A66 Northern Trans-Pennine Project

4.5 Statement of Common Ground North Yorkshire County Council and Richmondshire District Council (Rev 2)

24 January 2023

**4.5 JOINT STATEMENT OF COMMON GROUND WITH
NORTH YORKSHIRE COUNTY COUNCIL AND
RICHMONDSHIRE DISTRICT COUNCIL**

Drawing file: TR010062 / TR010062-000556-5.20 Classification of Roads Plan Scheme 09 Stephen Bank to Carkin Moor.pdf

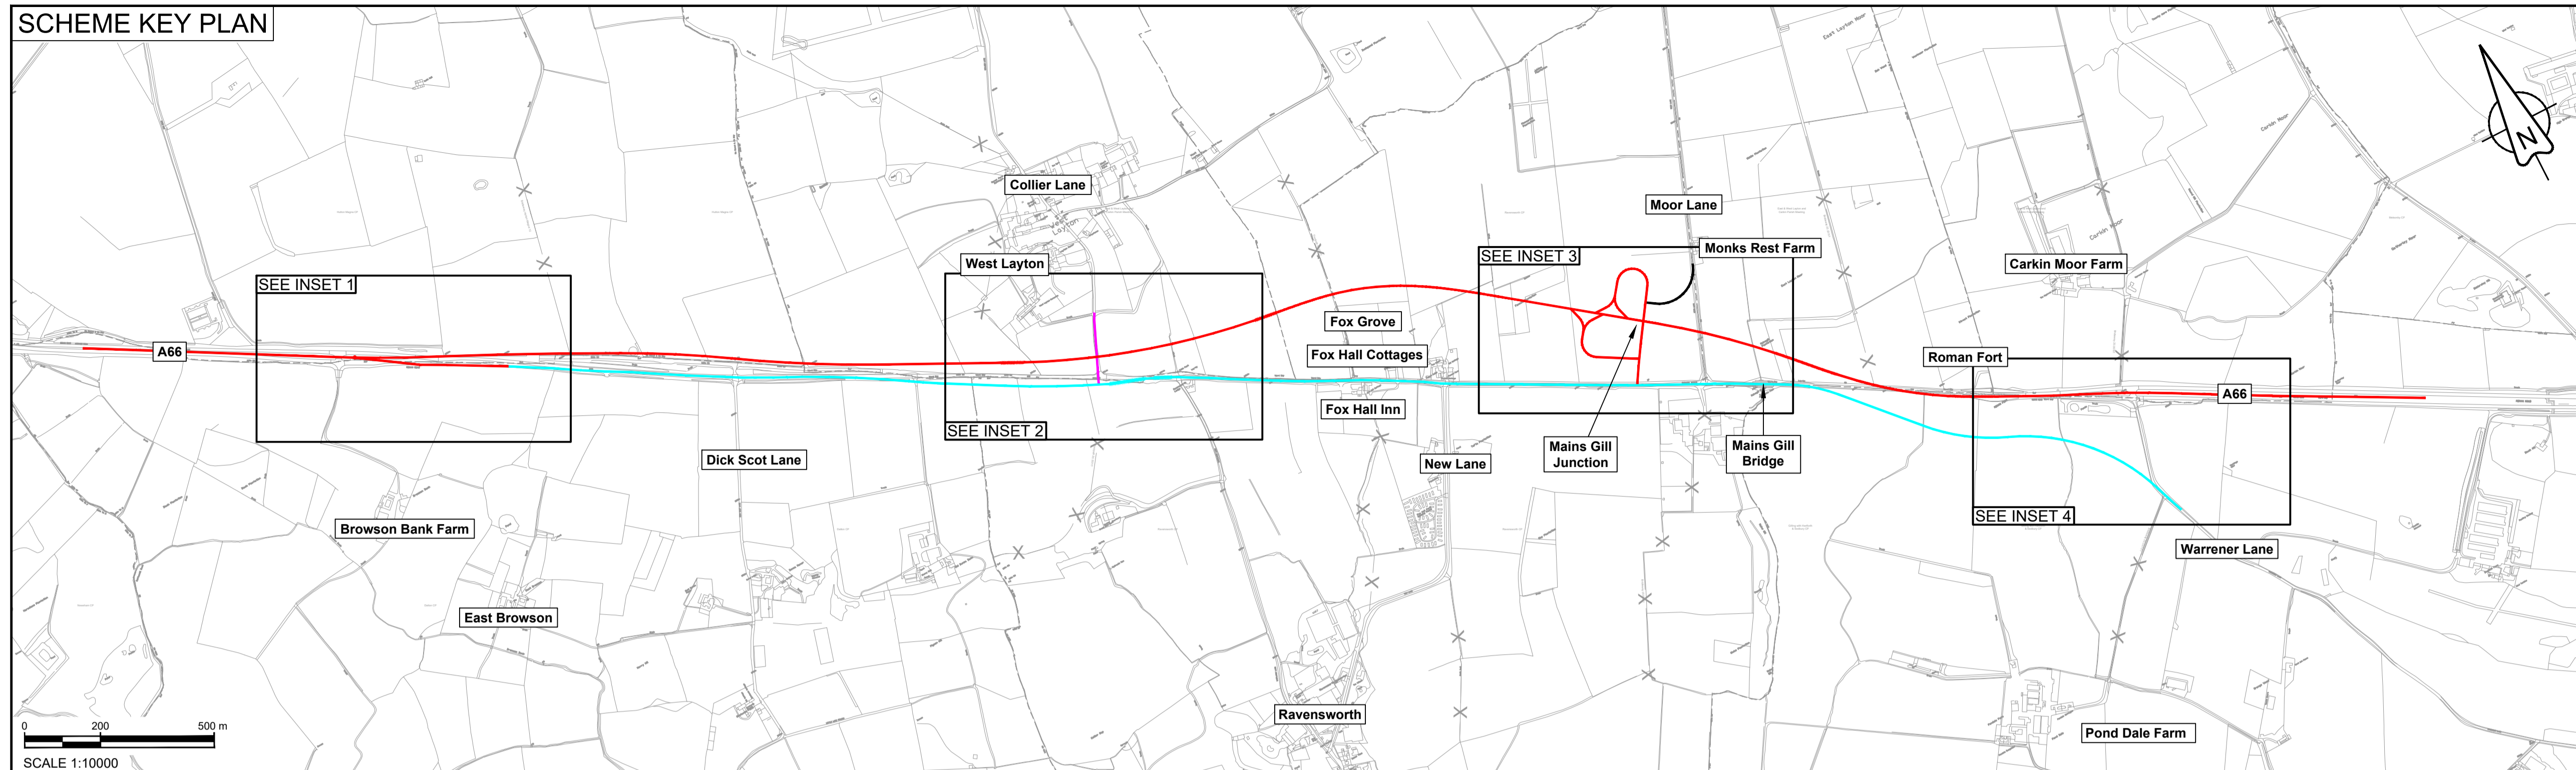
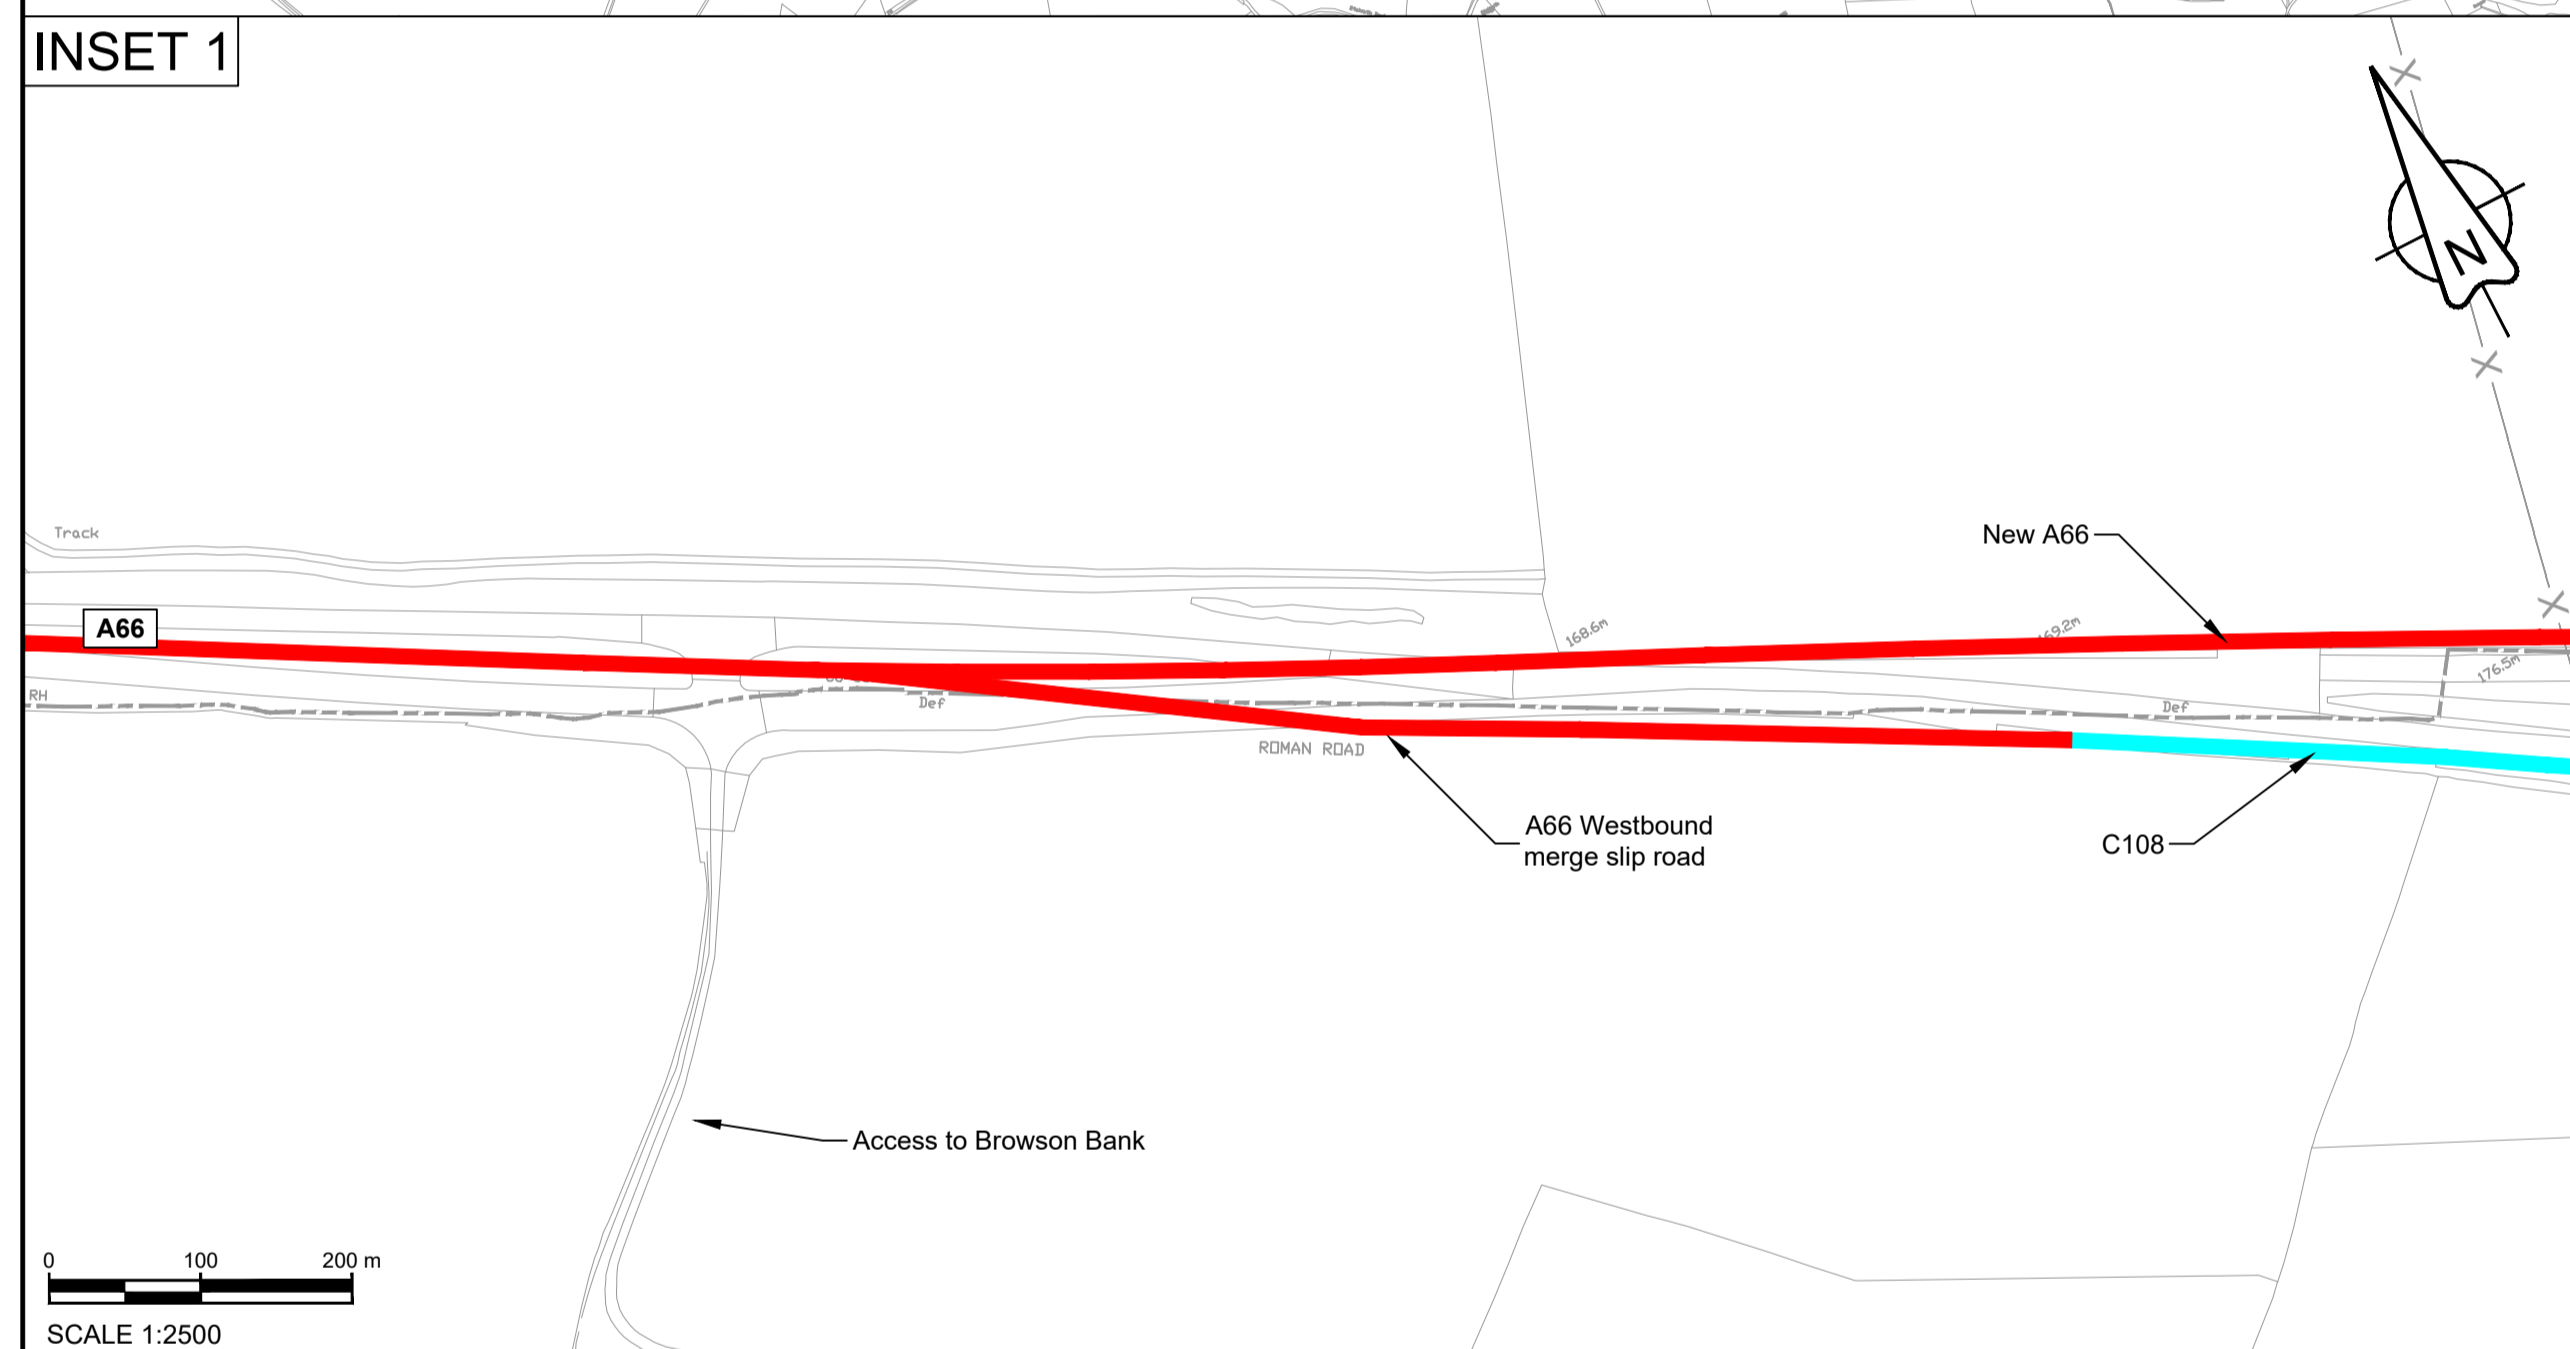
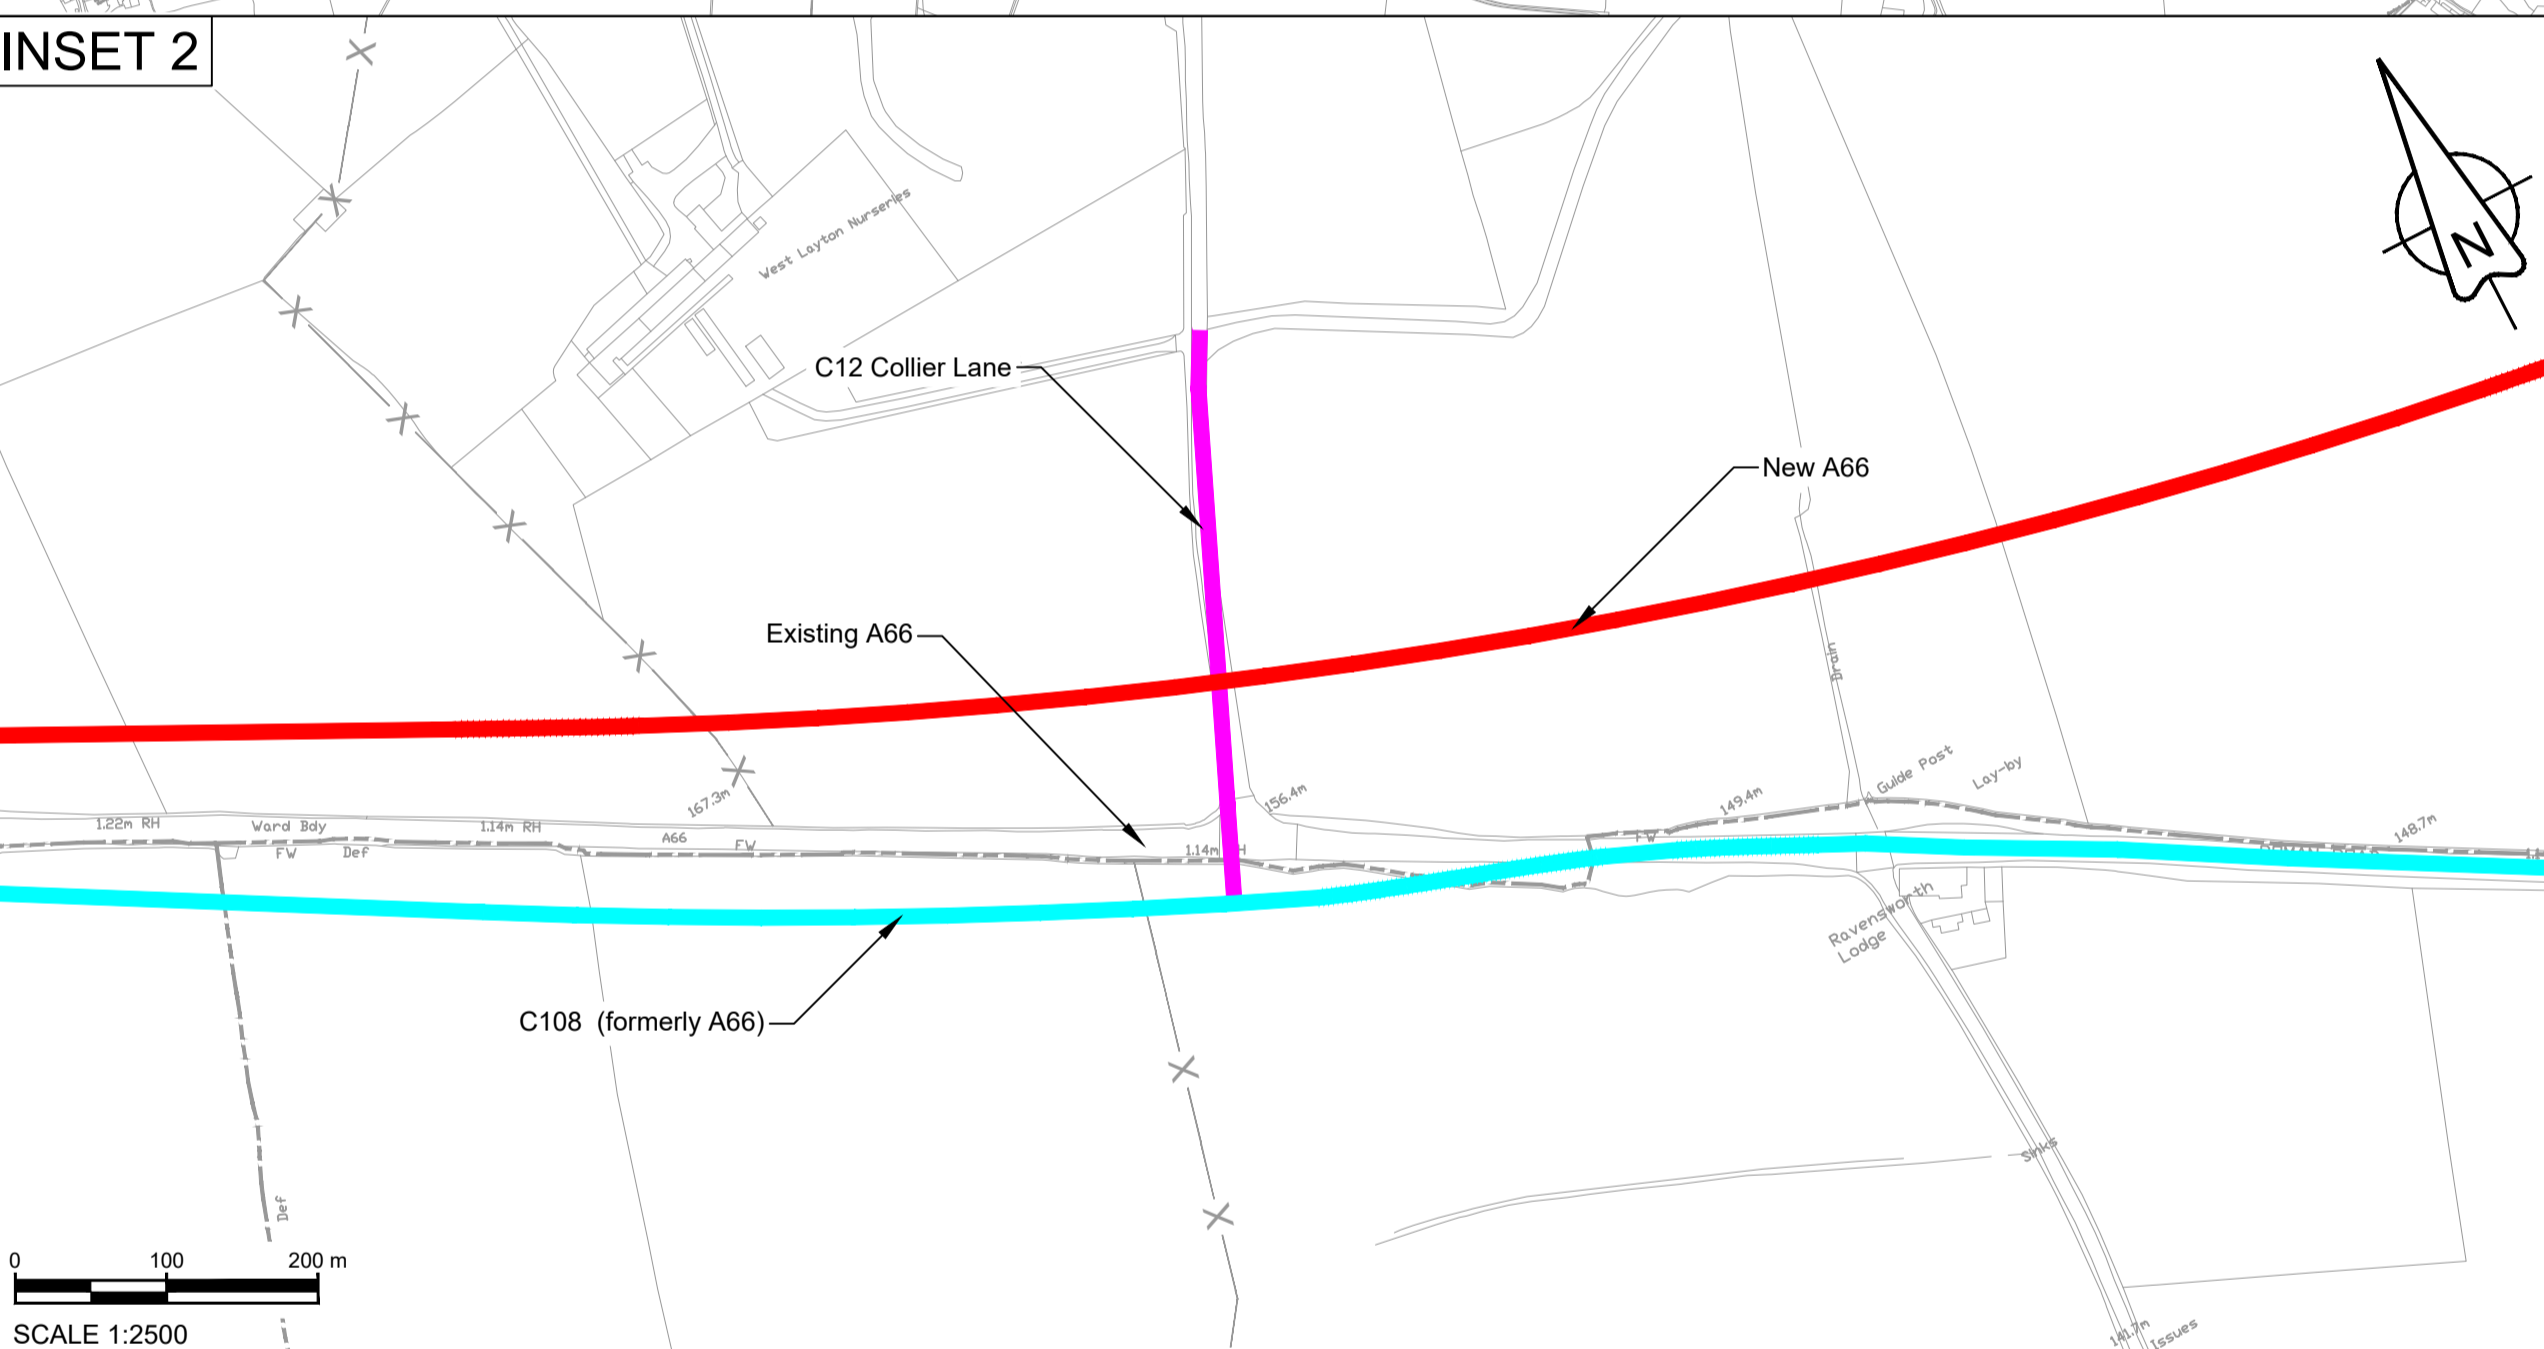
<p>3-2.14. Classification of Roads Plan</p>	<p>North Yorkshire CC & Richmondshire DC: Design Drawing Review Session</p>	<p>NYCC are happy with the C1108 and the extension of Warrener Lane, but we will seek to confirm with the team to ensure we are happy with this convention prior to those appearing on the schedules.</p>	<p>We will continue to seek confirmation on this matter.</p>	<p>Under discussion</p>	<p>13.06.2022</p>
<p>3-2.15. Traffic Regulation Order (Speed Limits) Plans:</p>	<p>North Yorkshire CC & Richmondshire DC:</p>	<p>Warrener Lane would that new stretch be at 50mph and will this leave us with an issue as to when</p>	<p>We will continue to seek confirmation on this matter.</p>	<p>Under discussion</p>	<p>13.06.2022</p>

3-1.7. Classification of Roads Plan: Moor Lane (and other Unclassified Road) junctions to the National Highway	North Yorkshire CC & Richmondshire DC: Design Drawing Review Session	Concern for Moor Lane (and other unclassified roads) what standards will these be built to. Issues previously where the access is to a high standard before hitting a smaller, unclassified road. This may need to be a departure to make this a narrow road.	The junction at Moor Lane would be built to a NYCC Design Standard rather than to DMRB to address this concern. This was the position agreed prior to submission of the DCO and will be integrated into the detailed design of the scheme.	Agreed	24.01.2023
